## **RESPONSE TO REQUEST FOR FURTHER INFORMATION WOOLWORTHS WAREHOUSE AND CUSTOMER FULFILMENT CENTRE, MARRICKVILLE (SSD-10468)**

This letter responds to the Request for Additional Information ('RFI') letter issued by the Department of Planning and Environment ('DPE') dated 10 November 2021.

Table 2 – Response to Inner West Council Response to Submissions Report

Drawing Name:
Landscape Soil Volume Plan

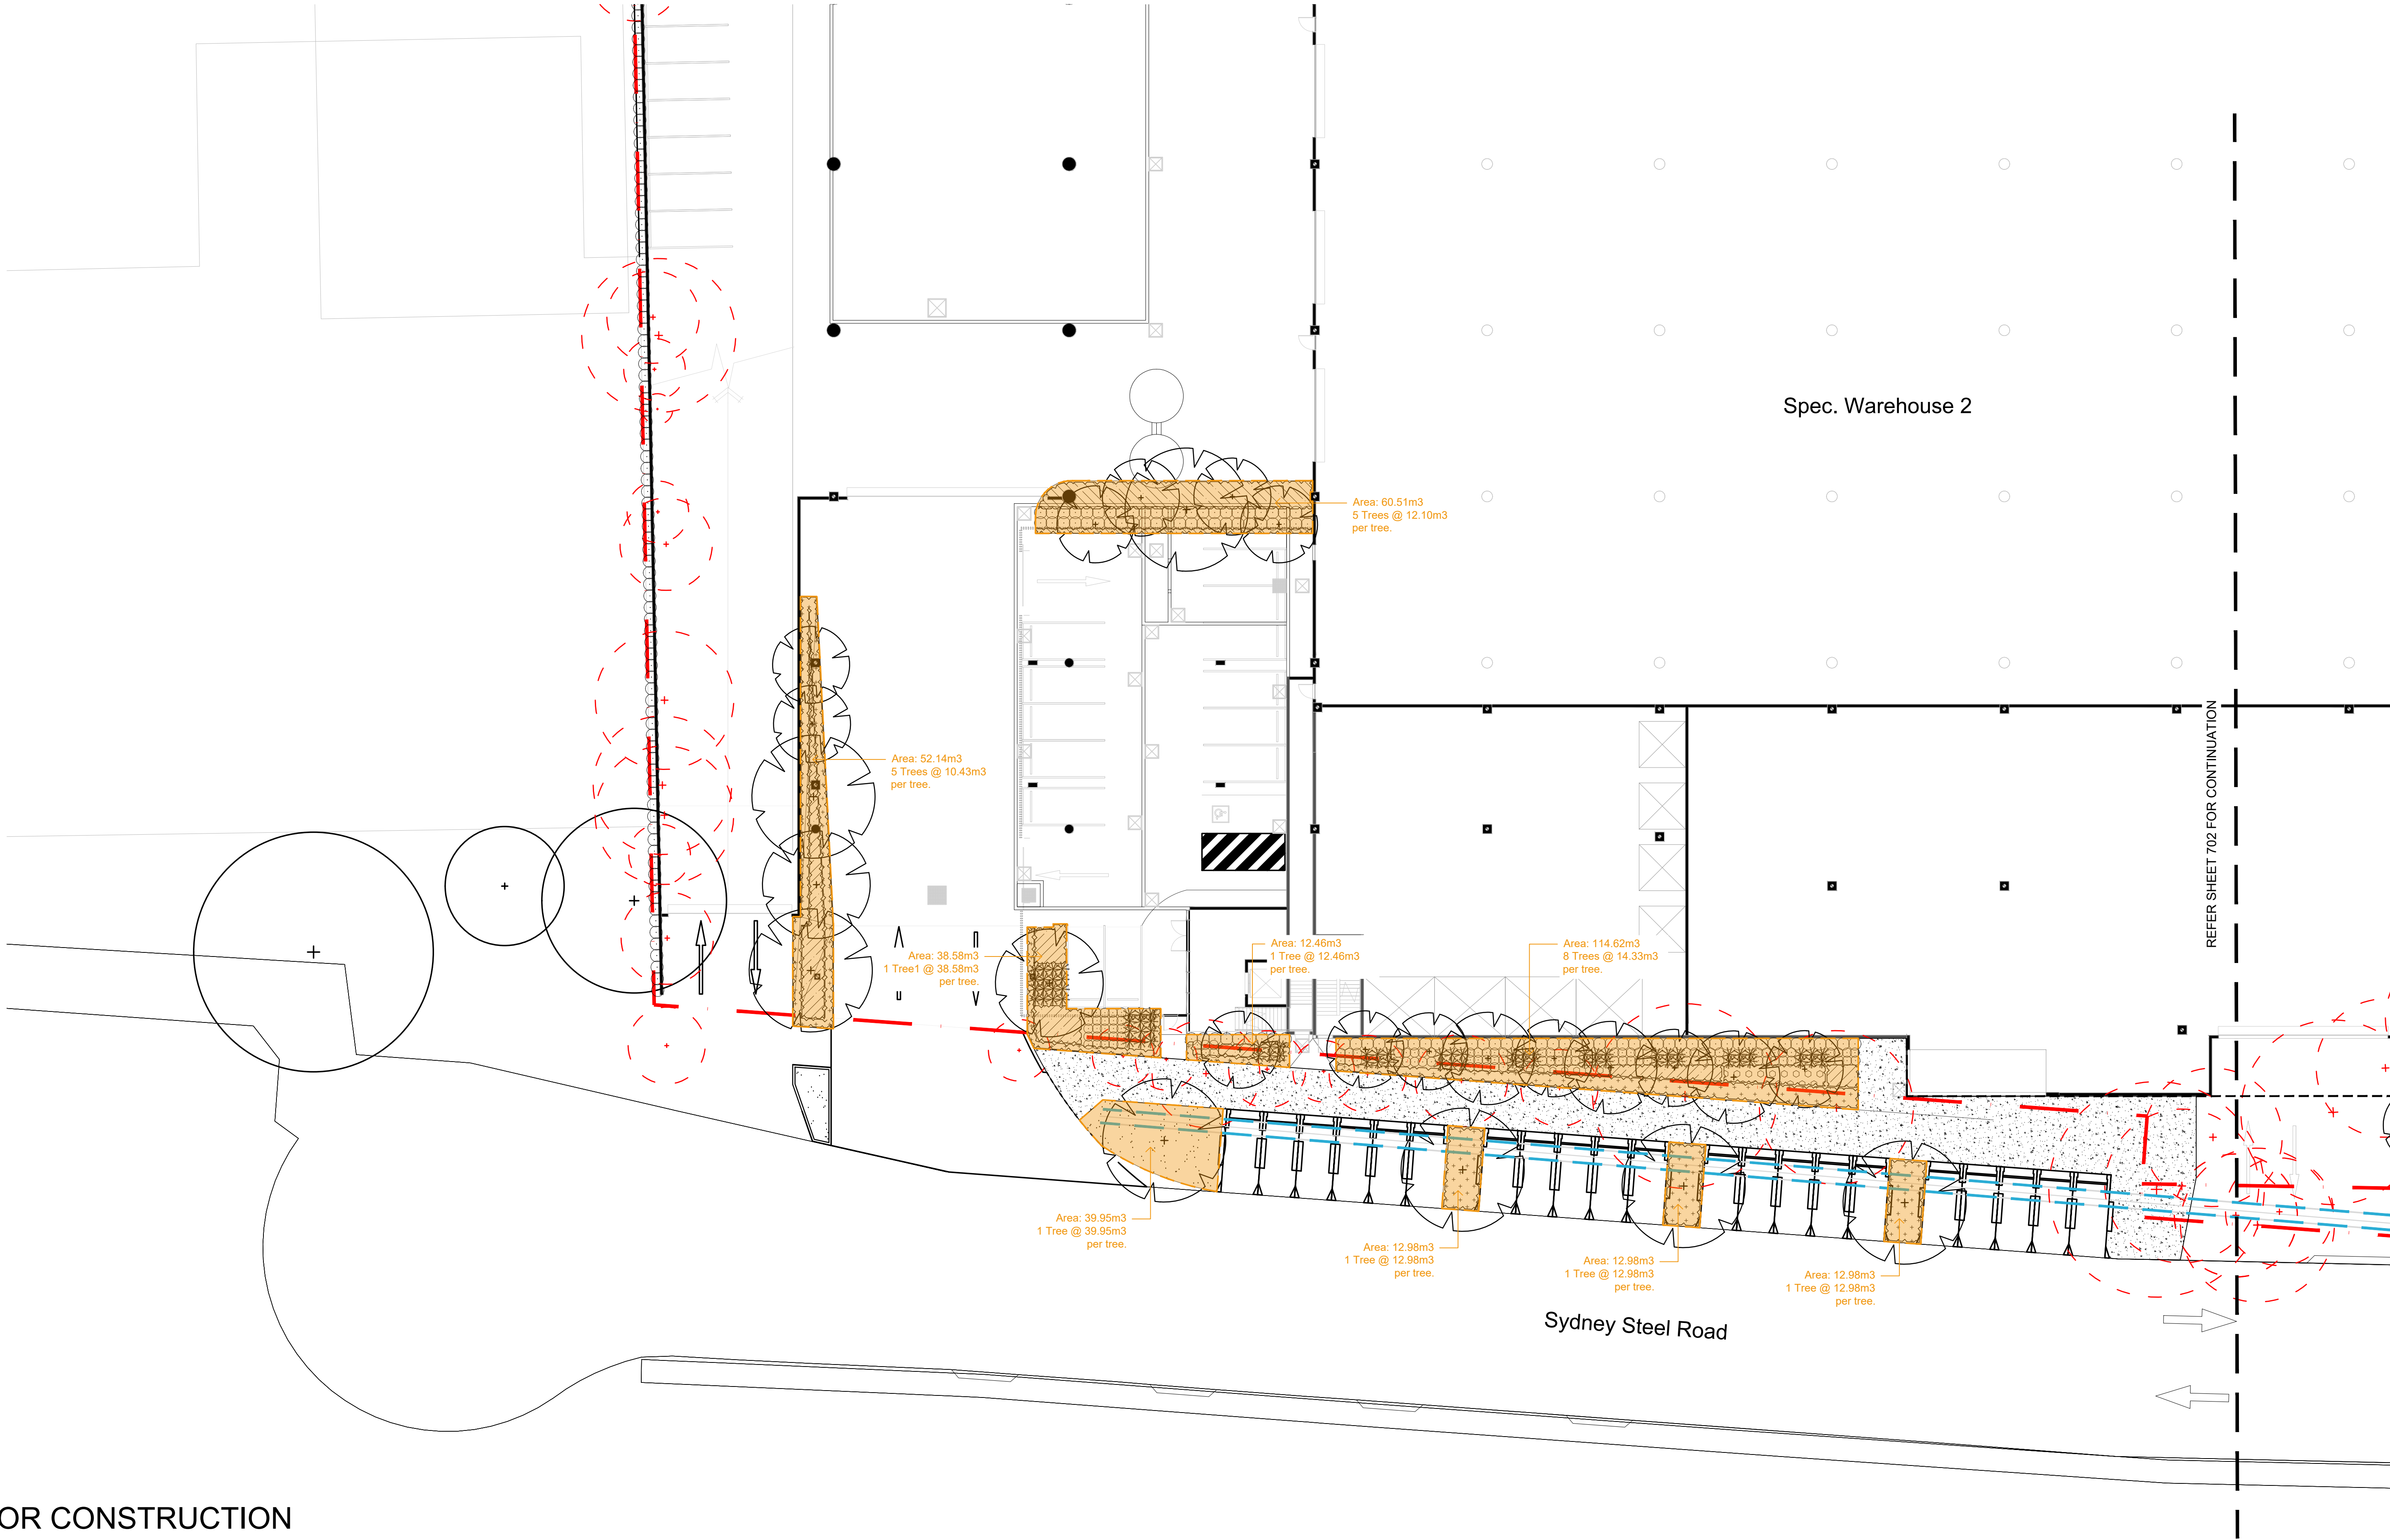
<p>vii. Relocation of stormwater culvert – The proposed location of the culvert is not supported because of the direct impact this will have on soil volumes available for the replacement streets on Edinburgh Road and internal landscape trees along this street frontage. The culvert location must be amended so that required deep soil volumes for trees are not constrained. The removal of the existing trees cannot be supported unless the trees are to be replaced in a viable growing environment.</p>	<p>The stormwater culvert has been realigned to be located within the property boundaries, enabling new street trees to be delivered within the road reserve.</p> <p>Updated landscape drawings have been prepared by Site Image dated 24 February 2022 (Rev F) which include the new stormwater channel location and the proposed street trees.</p> <p>The updated site plan (refer Sheet 401) shows the proposed location of the new street trees along the Edinburgh Road and Sydney Steel Road frontages. The sections</p>

Comment	Response
	<p>(refer Sheet 402) show the separation distances between the proposed culvert and the service zone location, footpath pavement and street tree planting along the Edinburgh Road frontage. Additional details regarding the tree soil volume areas for both the on-site and street tree planting has also been provided (refer Sheets 701-703).</p>
<p>viii. Soil volumes for trees – The Landscape Plans/Landscape Report must include soil volume calculations demonstrating that street trees and site trees have sufficient soil volumes to allow for the development of healthy root systems. Note – Medium trees ideally require approx. 27-38m<sup>3</sup> and large trees approx. 27-39m<sup>3</sup> (each) depending on soil conditions. Where trees are planted in shared contiguous planting zones and irrigated the soil volumes may be able to be reduced.</p>	<p>Updated landscape drawings have been prepared by Site Image dated 24 February 2022 (Rev F) including additional details regarding the tree soil volume areas for both the on-site and street tree planting (refer Sheets 701-703).</p> <p>The soil volumes are calculated based on the planter bed area and a depth of 1 metre. Where multiple trees share a planter bed, the volume has been divided by the number of trees to provide the volume per tree. These calculations are conservative, noting additional soil depth is available where trees are planted on grade and can access soil in adjacent areas.</p> <p>Overall, it is considered sufficient soil volume will be available to facilitate the development of healthy root systems based on the proposed site conditions, including the garden beds and additional soil volumes in adjacent areas.</p>

PROPOSED CULVERT RELOCATION	
DATE: AUGUST 2020	DRG.No. C20
SCALE: 1:500 @A1	REV-C
Project No. 190372

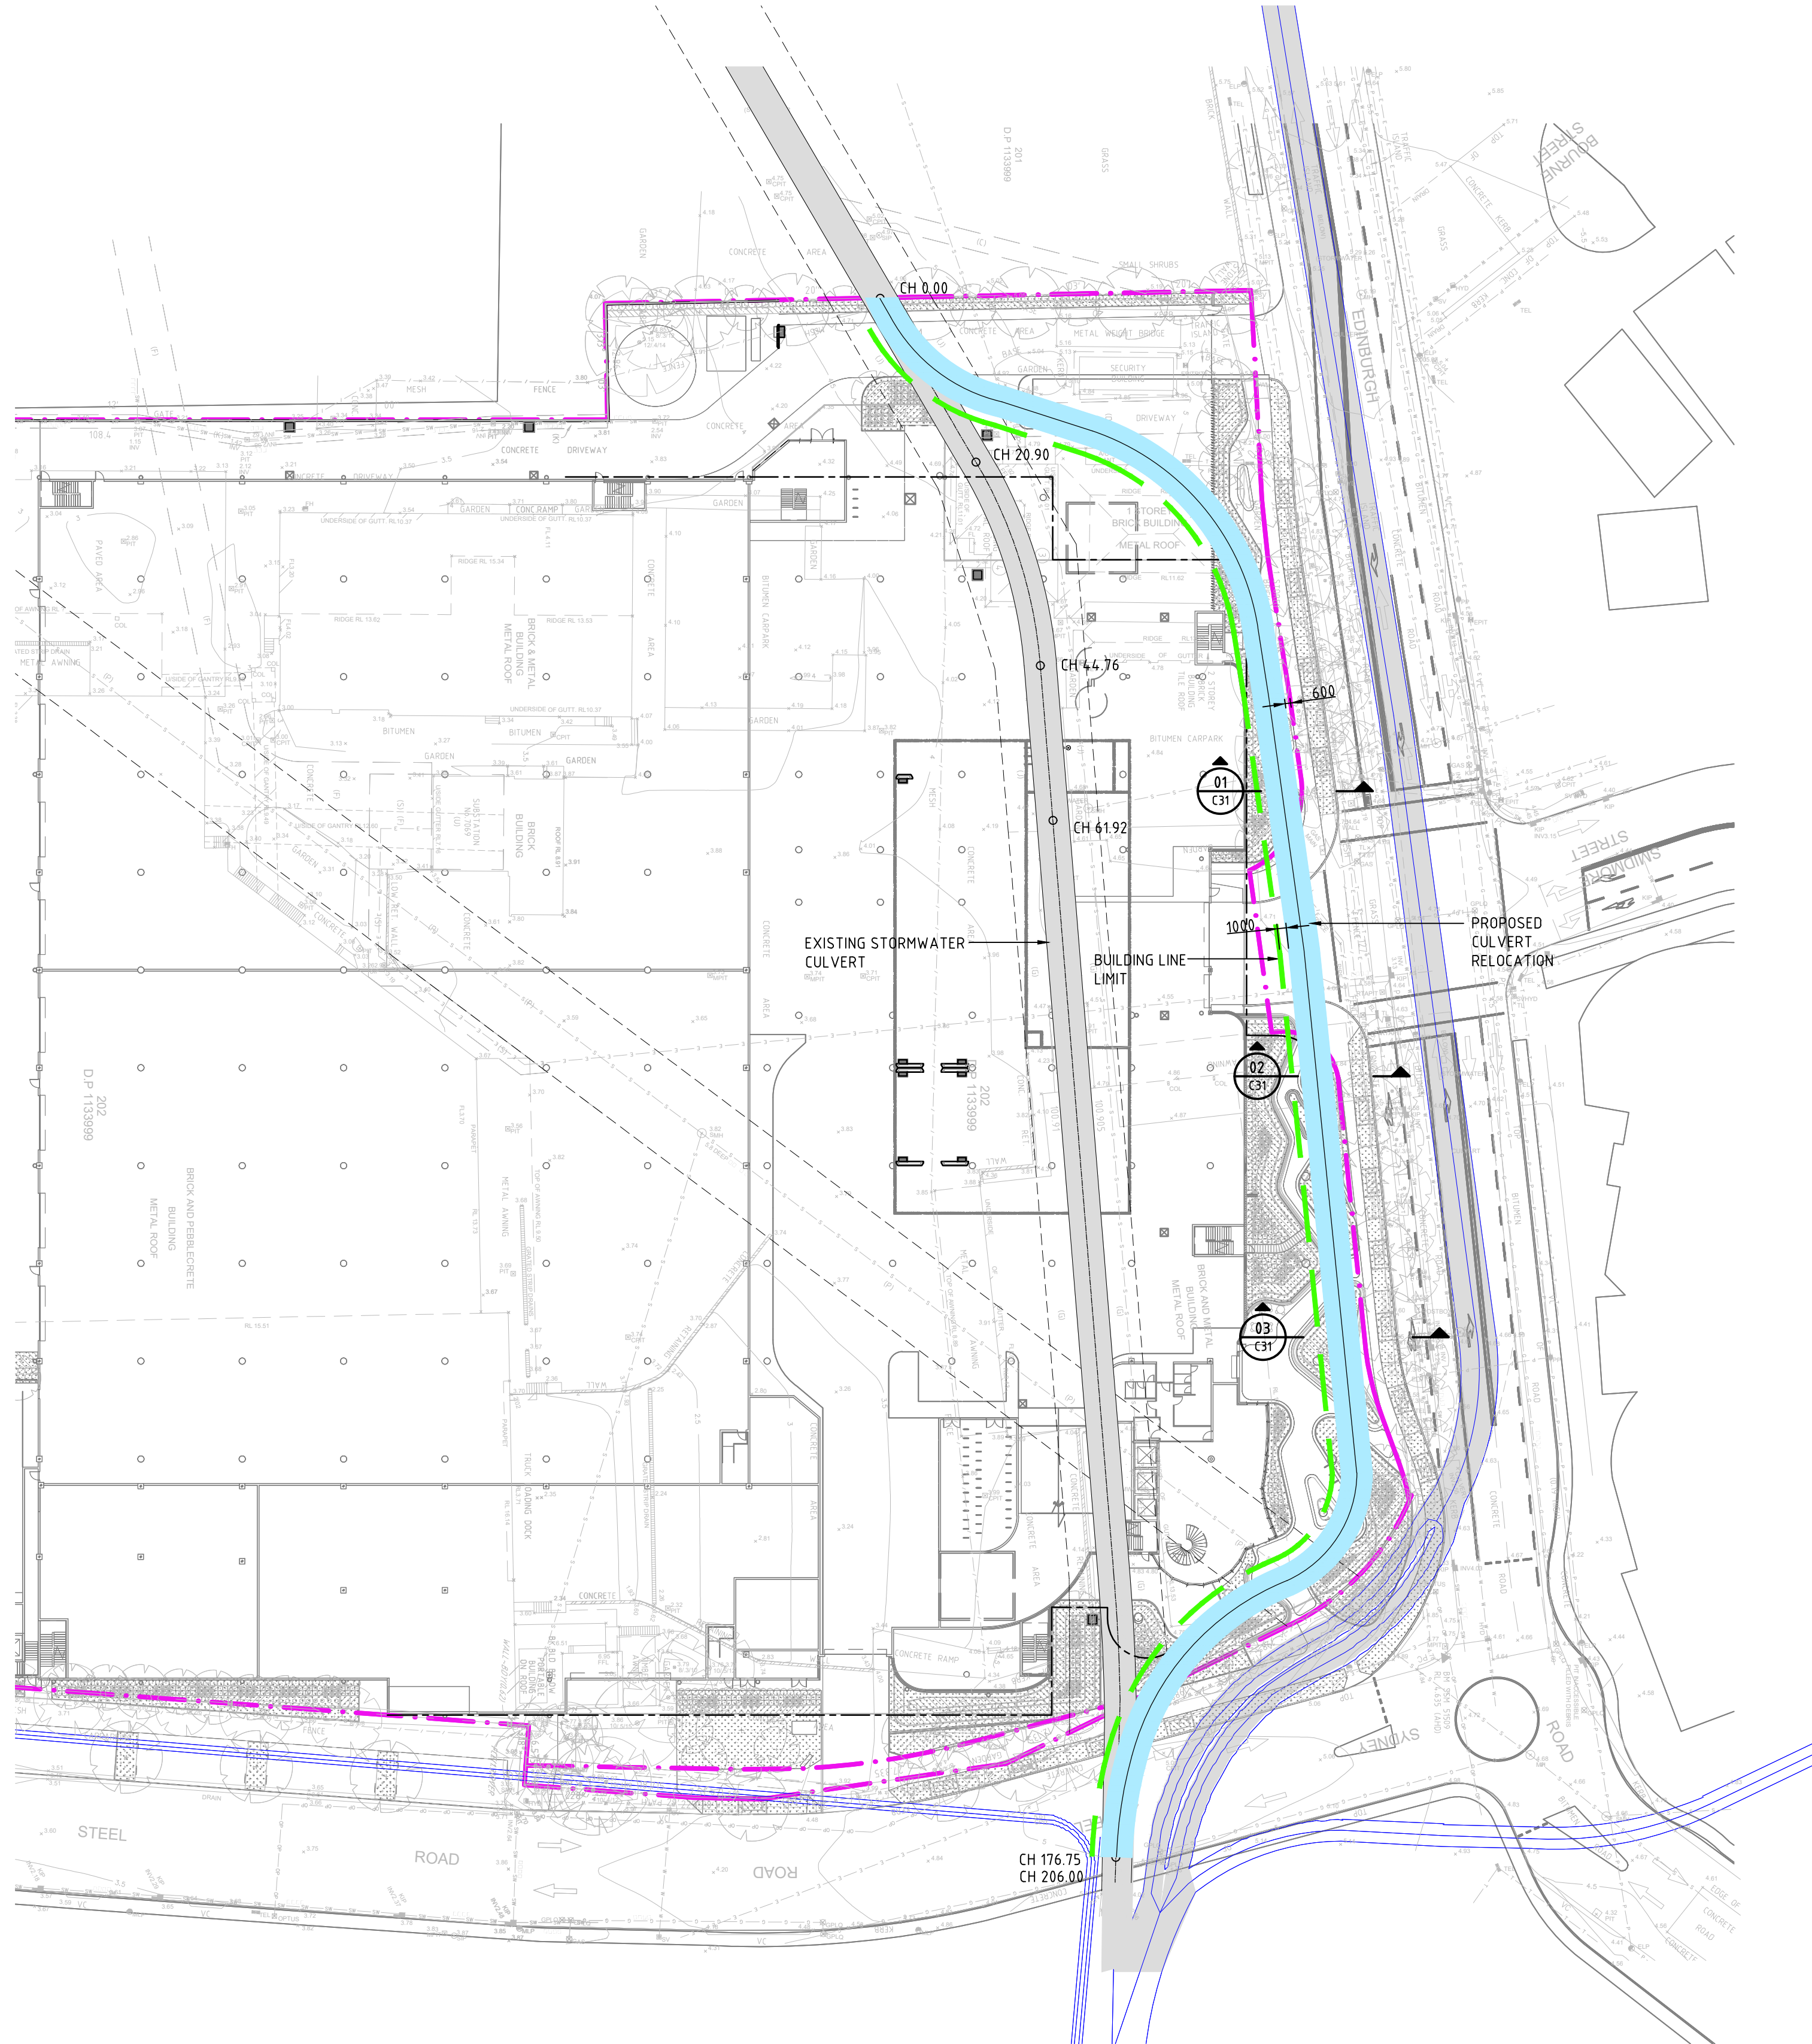
Comment	Response
<p>ii. The channel will be 3000mm wide (assumed internal) and close the surface. No details on cover available over the channel have been provided. The width of the channel will take up the full width of the footpath leaving little room for existing and proposed services in the footpath. In addition due to the width and minimal cover over the channel no meaningful landscaping and trees can be planted. In addition, there will be no room for the relocation of services within the footpath. The existing footpath has Ausgrid power cables and poles, Council stormwater pits and pipes, 150mm water main, Telstra and NBN cables etc. The proposed relocation of these services needs to be detailed on future submission.</p>	<p>The updated/final Civil Drawings prepared by R&amp;R include the stormwater channel within the property boundaries, generally parallel with the north-eastern setback to Edinburgh Road.</p> <p>The proposed culvert is located approximately 1000mm clear of the proposed services zone relocation below the footpath pavement and will not impact on the provision of trees or landscaping within Council's Road reserve.</p> <p>The updated Civil Drawings dated 28 January 2022 (Rev E) were confirmed as acceptable by Council in emailed correspondence on 4 February 2022. These drawings are consistent with the latest version (Rev F, dated 2 March 2022) which are consistent with the updated architectural and landscape drawings which include the final/agreed stormwater channel alignment.</p>

<p>iii It is doubtful that the proposed diversion of the channel will have the same hydraulic capacity as the existing channel given that the size is the same, the hydraulic losses produced by the double 90 degree bends and the fact that the grade of the channel has been reduced. This will need to be adequately modelled with a Hydraulic Grade Line Analysis provided to ensure that there are no impacts upstream of the channel bends. I note that the calculation shown on the stormwater plans have shown no loss in capacity by changing the value of Manning's "n" with no justification.</p>	<p>The previous culvert alignment was based on minimum 6 metre bend radius as requested by Sydney Water. The proposed culvert realignment has since been adjustment to eliminate the double 90 degree bends and increase the bend radius based on further consultation with Council.</p> <p>The existing culvert is of brick construction. The new culvert is proposed to be precast concrete. The Manning's 'n' values are based on typical roughness values for the existing and proposed materials. Concrete 'n' is 0.012 and brick 'n' is 0.015. Accordingly, the new culvert is smoother.</p> <p>The proposed grade is based on the start and end inverts at the connection point. As shown in the updated Civil Drawings</p>

Comment	Response
	<p>prepared by R&amp;R, parts of the existing culvert have a shallower grade than the proposed culvert. The shallower section of the existing culvert will govern the capacity of the culvert. The shallowest section of the existing culvert has a nominal unpressurised flow capacity of 5.818m<sup>3</sup>/s where the proposed culvert has a capacity of 9.719m<sup>3</sup>/s. Sydney Water have disregarded the surplus capacity and requested the dimensions match the existing culvert.</p>
<p><u>Traffic</u></p>	
<p>i. The Traffic Signals design shall be amended to include bicycle lanterns;</p>	<p>The bicycle lanterns will be addressed at the detailed design stage and in conjunction with any other detailed changes required by TfNSW as part of the design, review and formal approval process for the new traffic signal plan.</p>
<p>ii. Although an off-road shared pedestrian/cycle path has been shown on the plans it has not been designed to be a minimum width of 3 metres for its full length as previously advised. This must be shown on the plans.</p>	<p>Updated architectural drawings have been prepared by Nettleton Tribe which provide for a 3 metre wide pedestrian/cycle path along the full-length of Sydney Steel Road, linking to the existing pedestrian/cycle path on the northern side of Edinburgh Road and the existing pedestrian/ cycle path at the southern end of Sydney Steel Road through to Saywell Street/Shirlow Street and Sydenham Station.</p>
